Memorandum

To Anna Linnios
Date 04 April 2025
Copies Adam Marshall, Lauren Boysen
Reference number 298160-00
From Sina Hassanli
File reference
Subject o State Design Review Panel

Herein, please find a concise summary addressing the comments provided by the State Design Review Panel (SDRP) in their design review 5 relating to the Environmental Wind Assessment Report for Crows Nest OSD – Site B (Revision 5, dated 11 March 2025).

Figure 15: Classification of wind comfort and safety at 1.5 m above floor level for Level 4 representative balconies

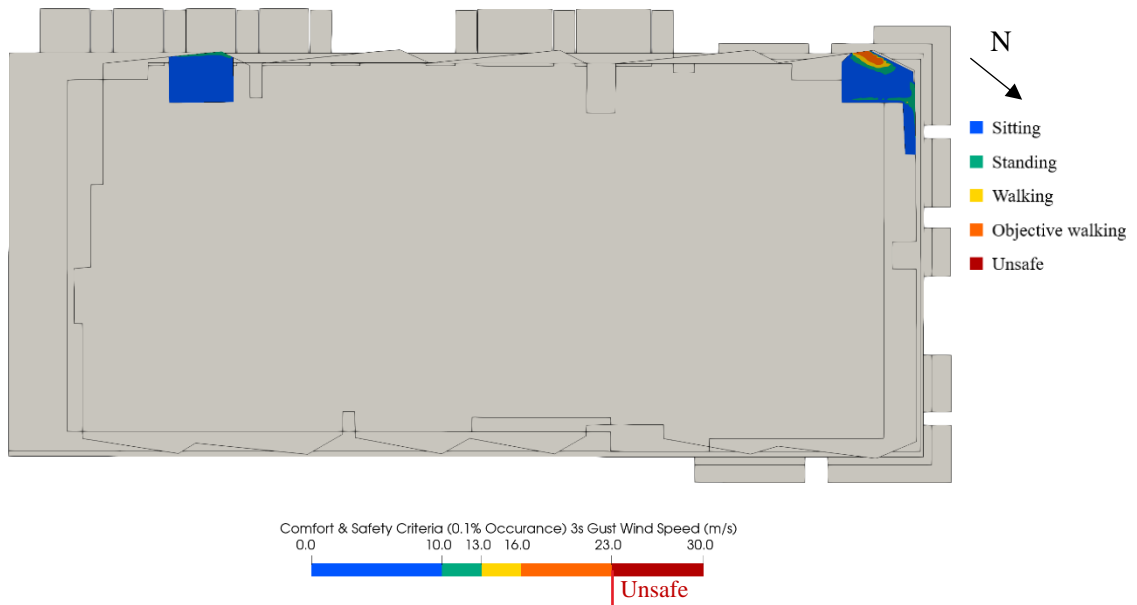
The wind report presents the wind conditions for the upper-level balconies in Figure 21, and for the mid- and lower-level balconies in Figures 39 and 40 (Appendix), respectively. Upper-level balconies are generally subject to higher wind speeds due to reduced shielding from surrounding structures and elevated exposure. As a general guideline, balconies should be designed to achieve *sitting* or *standing* (depending on its location) or better wind conditions across the majority of their floor area, with no areas classified as uncomfortable.

The analysis indicates that, aside from the north-east and south-west corner balconies, most balconies are suitable for *dining*-type activities (i.e., wind speeds below 2 m/s for 95% of the time or more). Even for the corner balconies, the inner half (at least 50% of the area) remains suitable for *dining*, with 80% of the area classified as suitable for *sitting*. As expected, higher wind speeds are observed at the more exposed corners; however, over 80% of the balcony area still experiences wind speeds below 2 m/s for more than 80% of the time, and more than 95% of the balcony area experiences wind speeds below 4 m/s (corresponding to *sitting*) for 90% of the time or more. Refer to the figure below, which presents the percentage of time the wind remains below 2 m/s and 4 m/s on the south-west corner balcony—the most affected by wind (0-1 equivalent to 0-100%).

As these are privately accessed balconies, the conditions are considered acceptable, given that usage is likely to be minimal during very windy conditions. If further improvement is sought for corner balconies, one potential mitigation is to install a blade wall along one side.

Figure 17: Classification of wind comfort and safety at 1.5 m above floor level for Level 17 roof terrace

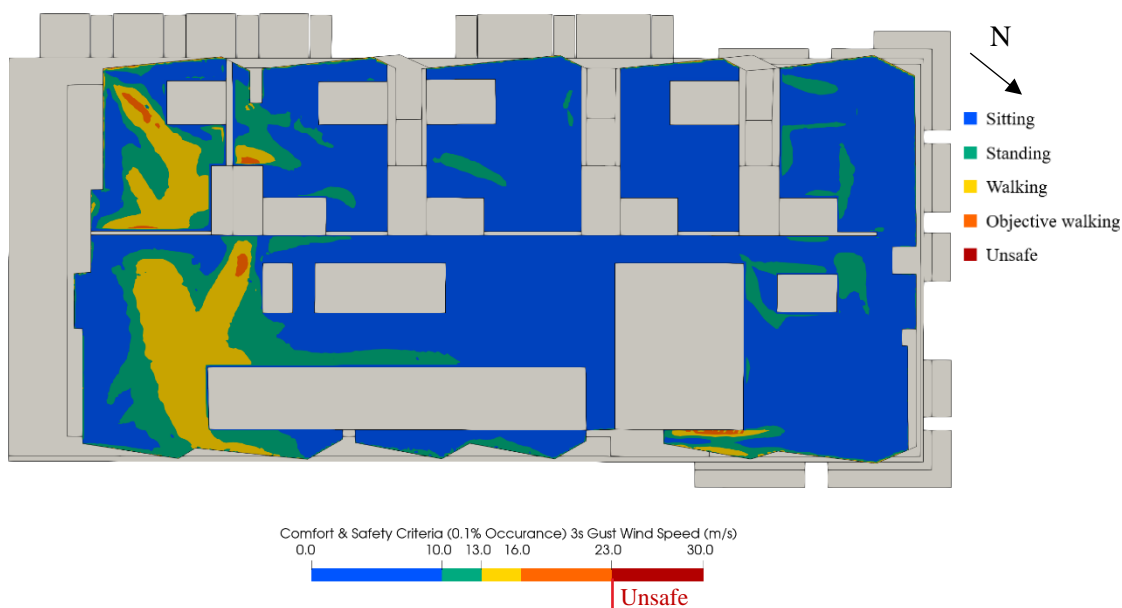
Not all areas on the rooftop terraces are typically intended for *sitting*-type activities. A certain degree of wind exposure and the presence of windy spots are generally expected in rooftop environments. The majority of locations on the rooftop are classified as suitable for *dining* or *sitting* activities. As such, it is intuitive that occupants would gravitate toward more sheltered areas during windy conditions, if such options are available.

That said, if areas classified as *standing* are indeed designated for seated use, there are potential mitigation strategies that could be implemented to improve wind comfort. Given that the winds at these locations are predominantly horizontal, the introduction of vertical barriers of adequate height can provide localised protection on their immediate downwind side.

For example, the location at the southern edge of the rooftop—classified as *standing*—is primarily influenced by winds from the SSW quadrant. Extending the existing vertical blade wall in this area could enhance wind conditions. Similarly, incorporating additional vertical elements through landscaping could further reduce wind impact and improve amenity. The area to the north of the rooftop classified as *standing* is affected by winds from the NNE quadrant (more frequent in summer time) is very localised and hence considered appropriate.
